RE: TCL comment explanation letter-7030 Holly Avenue NE

The following is a list of responses to comments dated June 9, 2023, from Marwa Al-najjar.

13 | enlarged bike rack plan
A001 1/2"=1'-0"

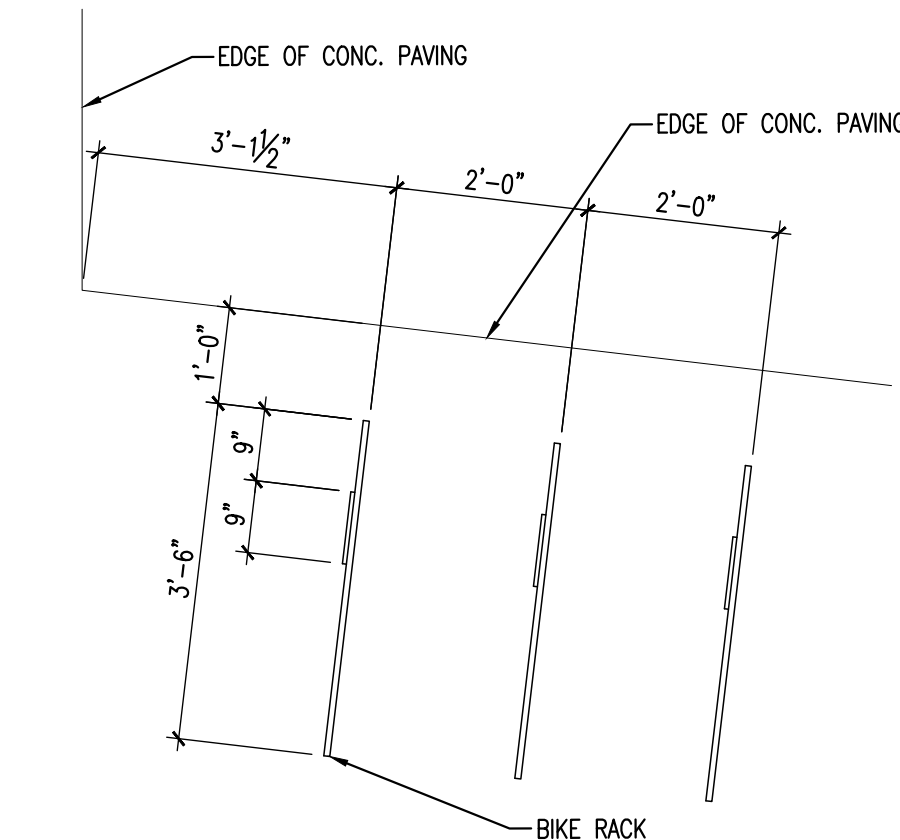
6. The bike rack shown complies with the requirements listed in a thru f.
7. The bike rack detail shows the bike rack is securely anchored.
8. The enlarged bike rack plan 13/A001 shows there is a 1' clear zone all sides of bike rack.

9. The bike rack spaces meet the 6' long x 2' wide requirement. See 13/A001 as well as the location on the entry plaza.
10. The keyway at the dead-end parking lot has been increased on the site plan from 4' to 5'.

12 | bike rack detail
A001 1/2"=1'-0"

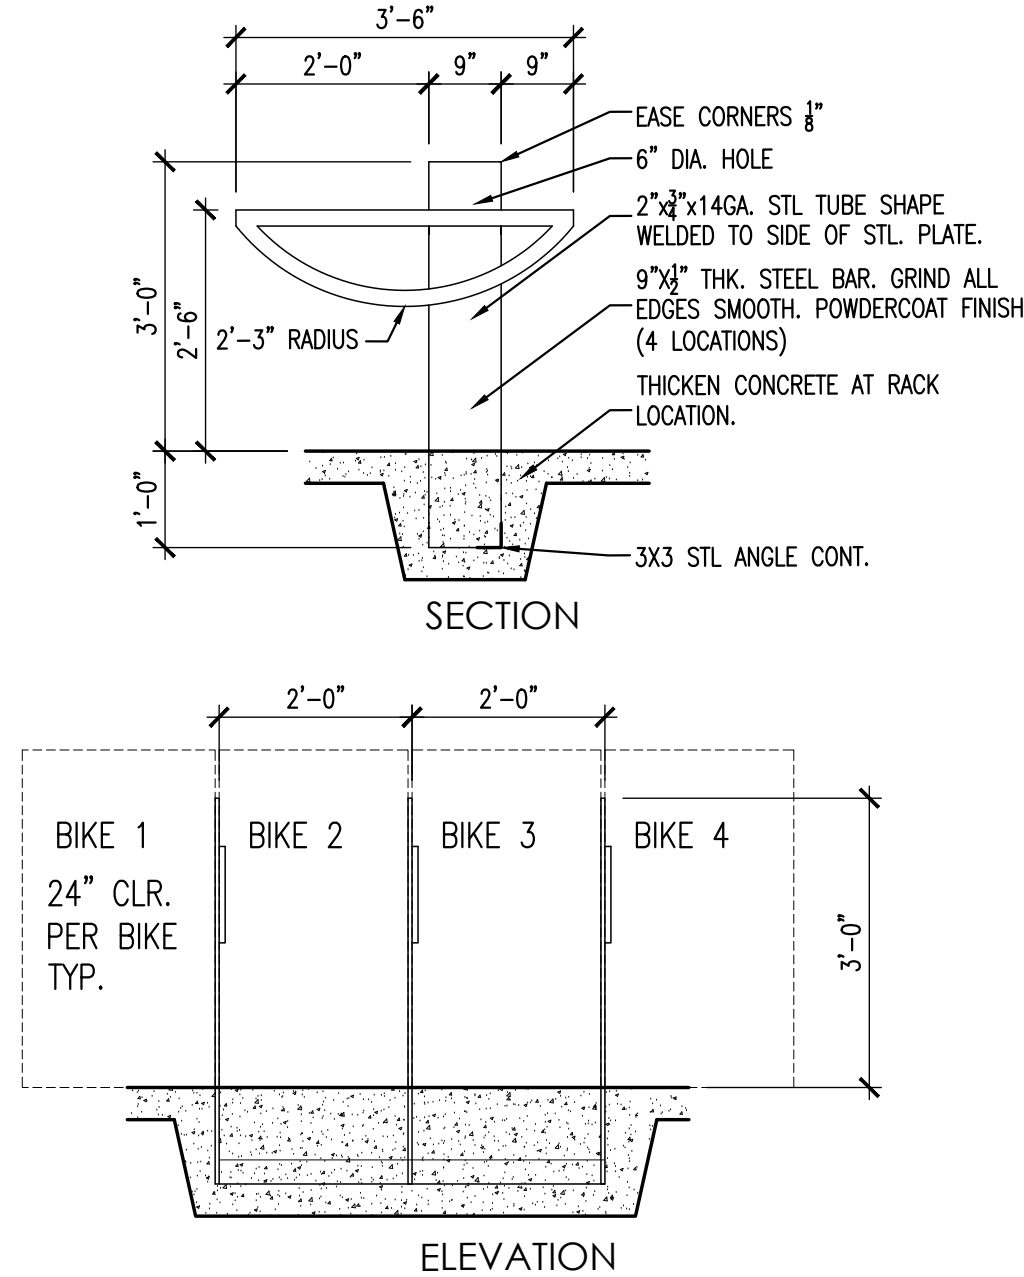
5. The bicycle rack location and detail have been added to sheet A001. The bike rack is not a standard detail; however, it meets the requirements outlined in the comment. See details 12/A001 and 13/A001. Keynote 30 has been added to the site plan.

5 | accessible parking detail
A001 1/8"=1'-0"

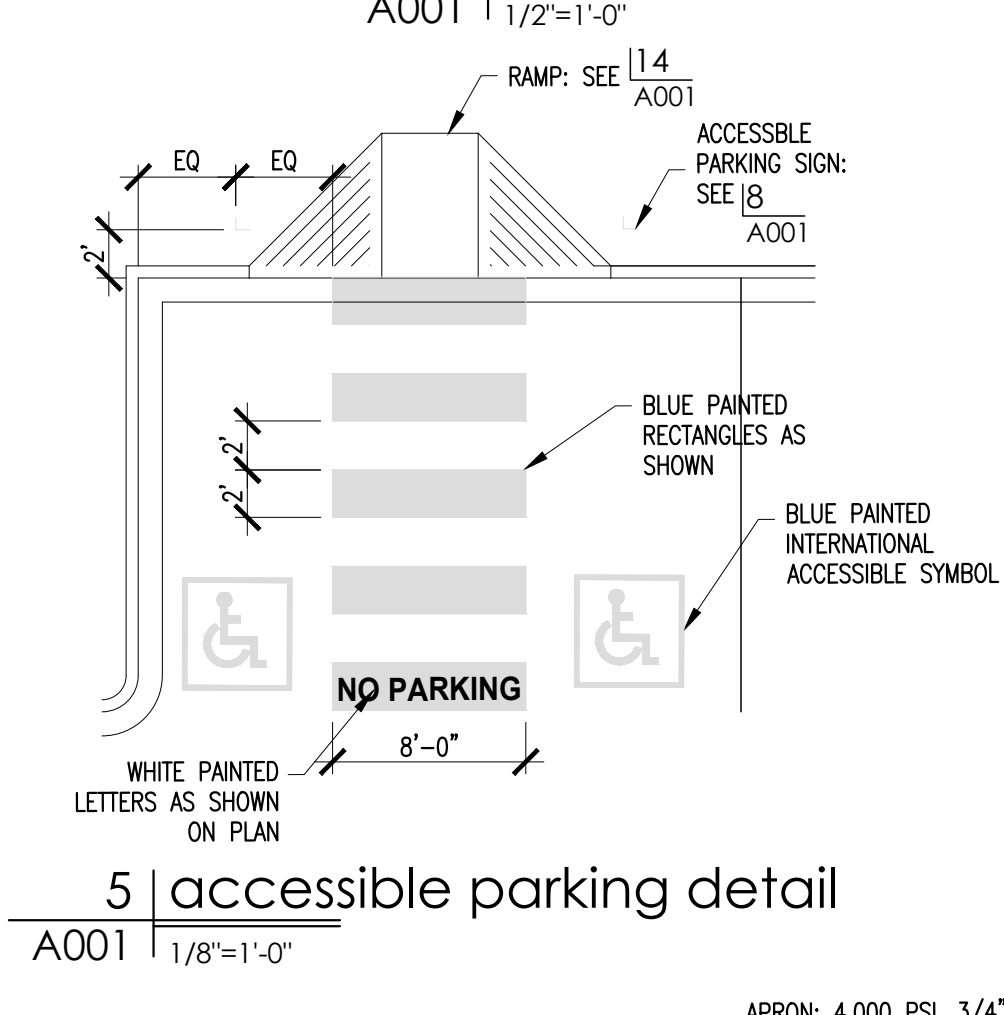
3. There is no sheet A002. All details are on sheet A001. A couple key notes incorrectly referred to sheet A002. This has been corrected.
4. The ADA compliant parking ramp detail has been added to the site plan. See detail 14/A001. A key has been added to detail 5/A001 as well.

1 | site plan
A001 1"=20'

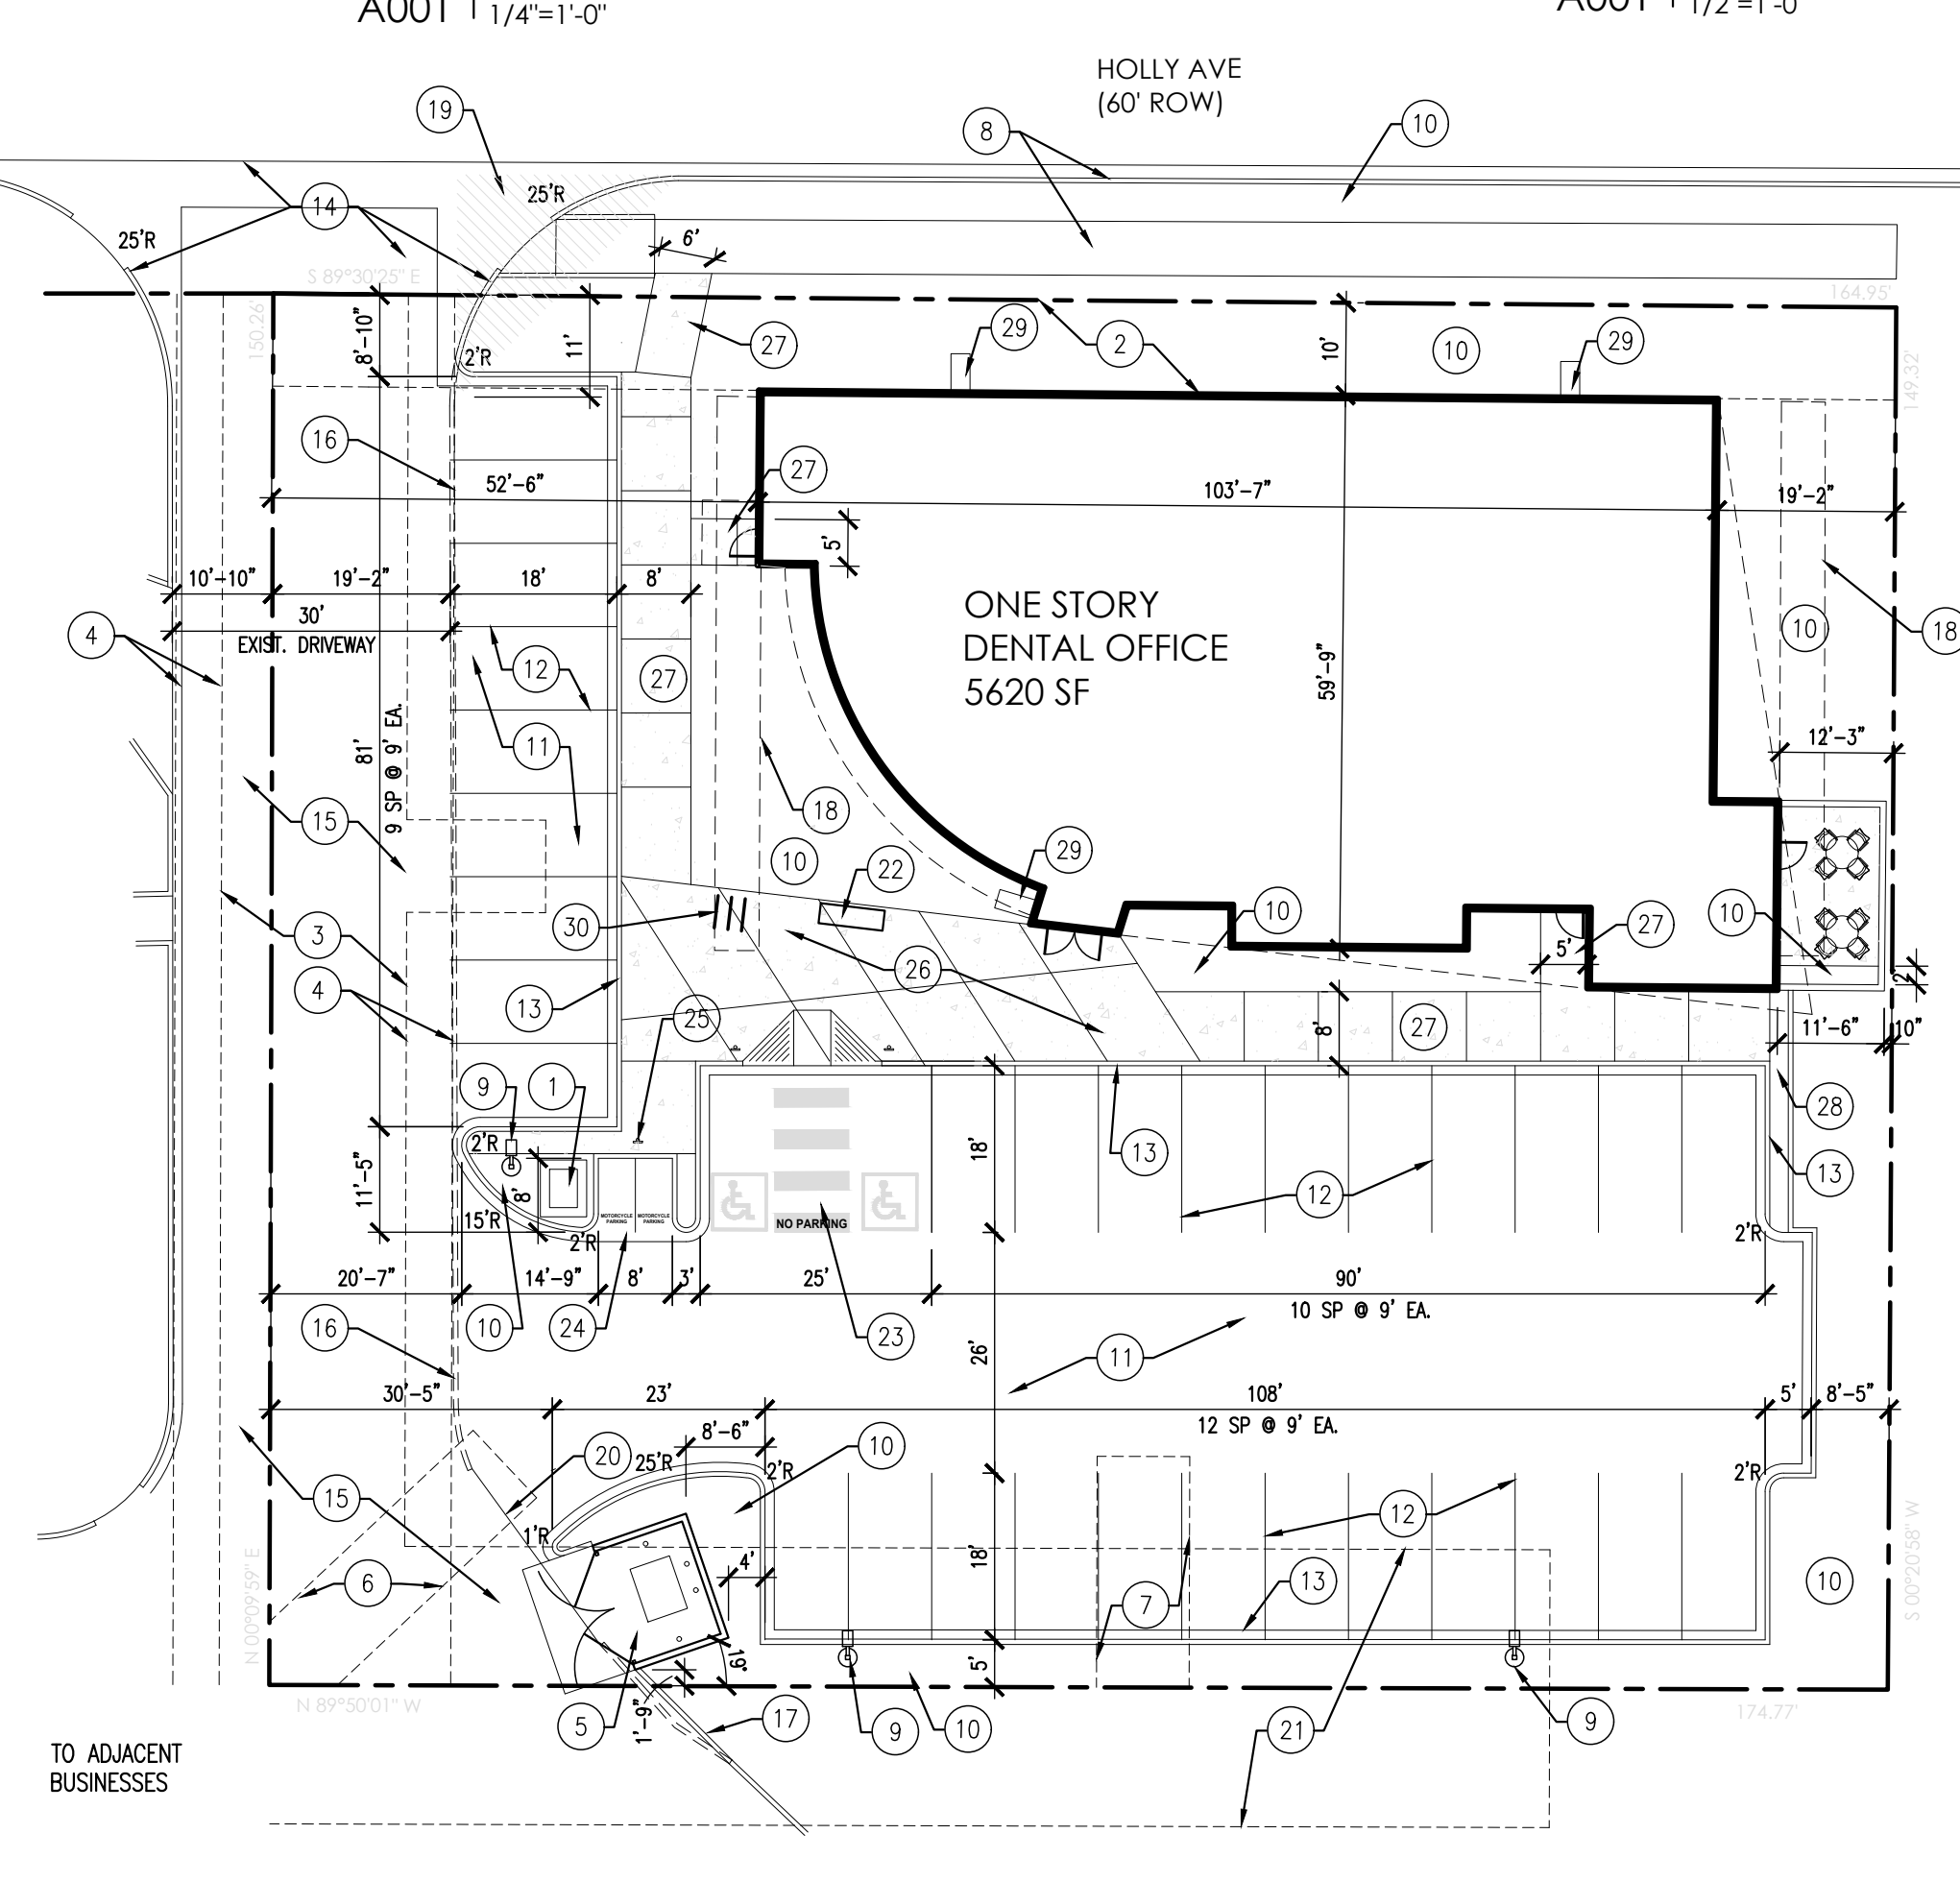
1. Keyed note 14 has been modified to add the note to install truncated domes. The existing ramp is in compliance per Std. Dwg. 2440 note 10.
2. The ALTA survey of the property is included as part of this resubmittal.

13. Standard drawing numbers have been added to key notes 8 and 14, which refer to existing construction in the right of way.
14. The requested note has been added to keynote 8, which refers to the existing sidewalk and curb and gutter.
